From: Juan Baeza
Sent: 18 January 2018 13:25
To: Planning.Responses
Cc: Amanda Scholes
Subject: WA/78/17/DOC

From: [REDACTED]
Sent: 18 January 2018 13:01
To: Paul Cann
Cc: Andrew Davey; Mark Willis; Des McCall; Jack Dexter; Juan Baeza; Daphne Hobbs-Green
Subject: RE: Walberton

Subject: RE: Walberton

Project: Red Cottage, West Sussex
Drawing No.: 536/501
Drawing Title: Typical Soakaway Section A-A
By: JD
Date: November 17

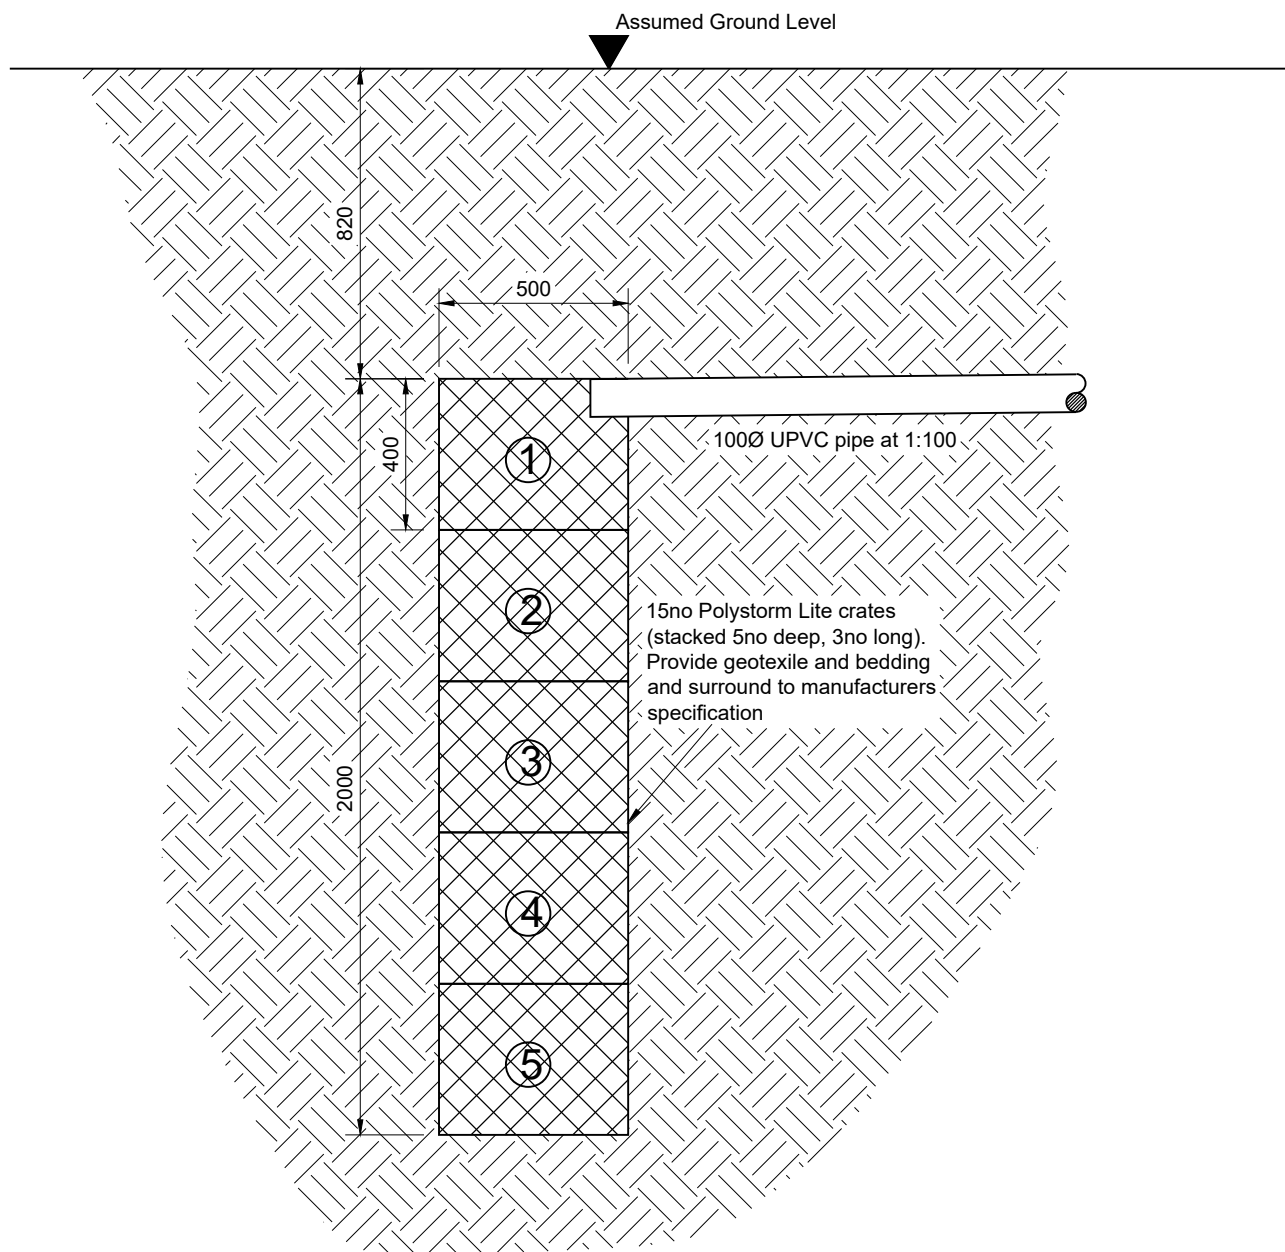
1. Please provide all the readings associated with the 13 minute percolation test ie. water level readings from 0 mins to 13mins, so the rate can be checked.
2. The storage calcs show a minimum soakaway depth of 1.944m being required. How can this be achieved based upon the design requirements. ie. soakaway base must not extend more than 2m below ground level and you also need to achieve adequate cover to the crates for protection.
3. Please show manhole cover/invert levels, including pipe invert at connection to soakaway.
4. Specify base level of soakaway ie. a level max. 2m below ground level.
5. Provide construction detail/section of soakaway (to include permeable geotextile wrapping).
6. Manhole SW4 is to be a catchpit (provide construction detail).
7. How is the driveway being drained? Provide full details/calculations.

| Drawing Title: | Site Plan Showing Below Ground Surface Water Drainage |

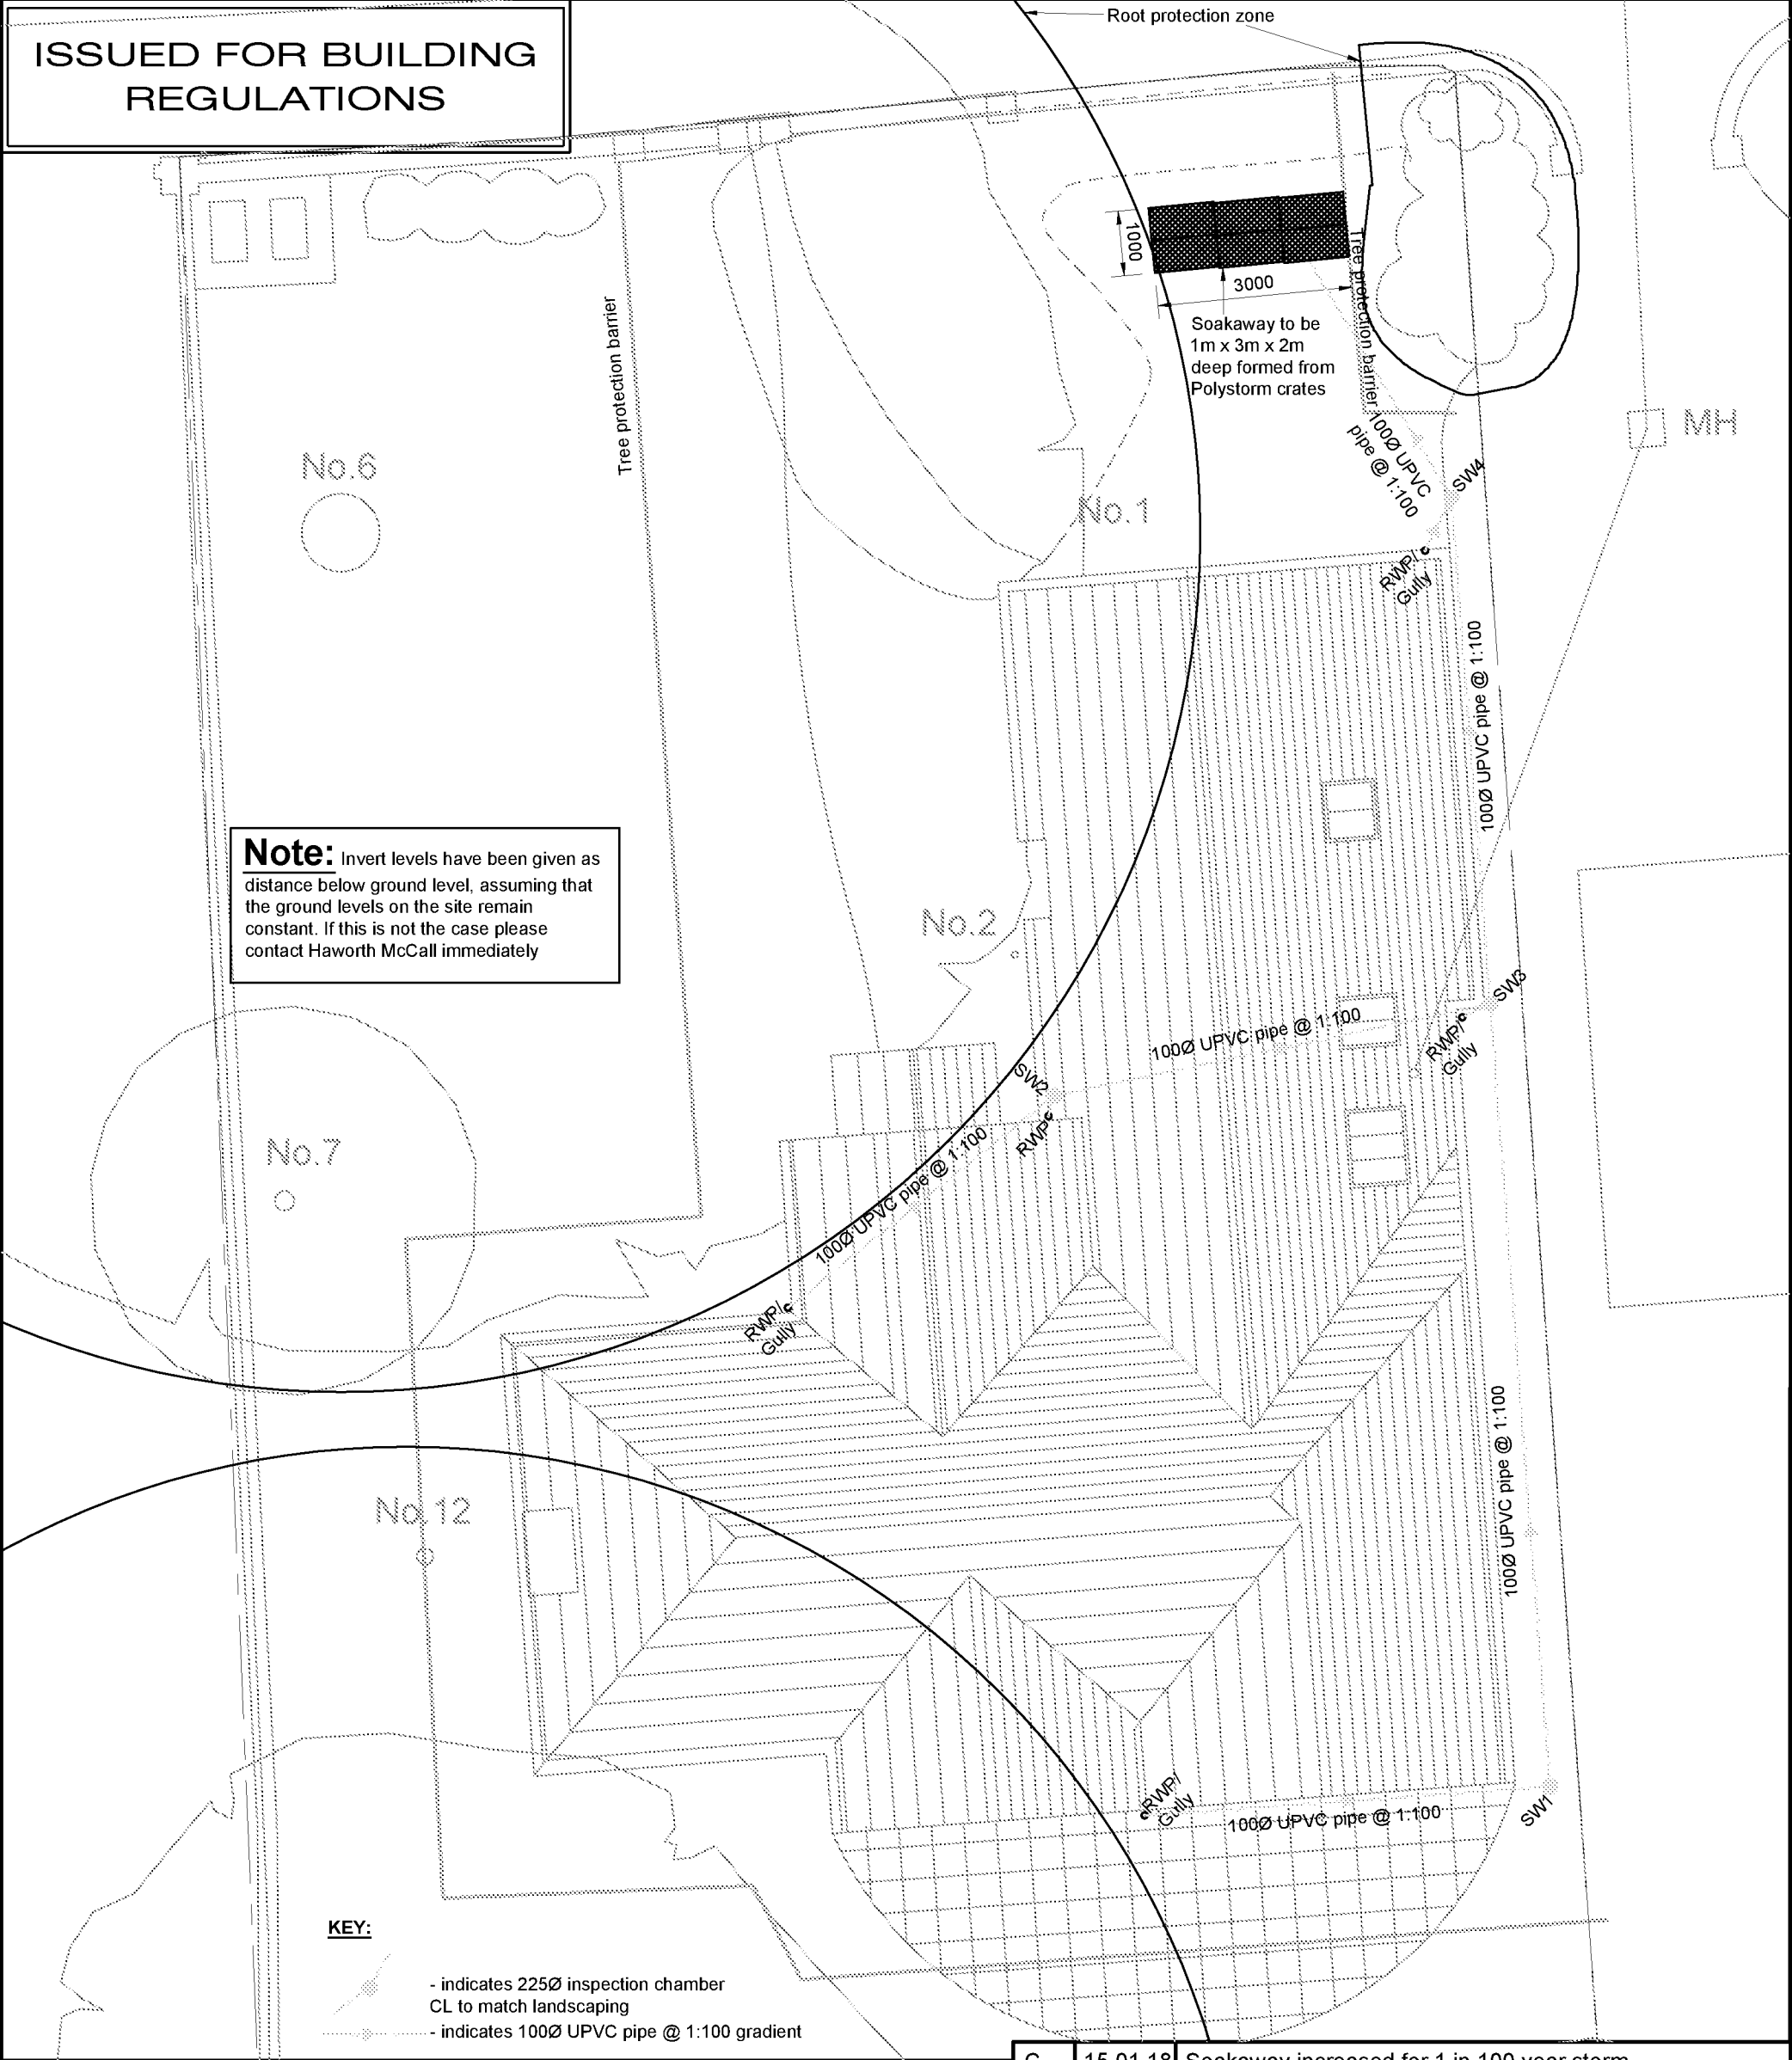
I look forward to receiving your design drawings (layout and construction details). Please note that the depth from ground level to the base of the soakaway must not exceed the depth of your trial hole.

Attached is our amended drawing and soakaway calculation show the soakaway size and position using the infiltration test results above.
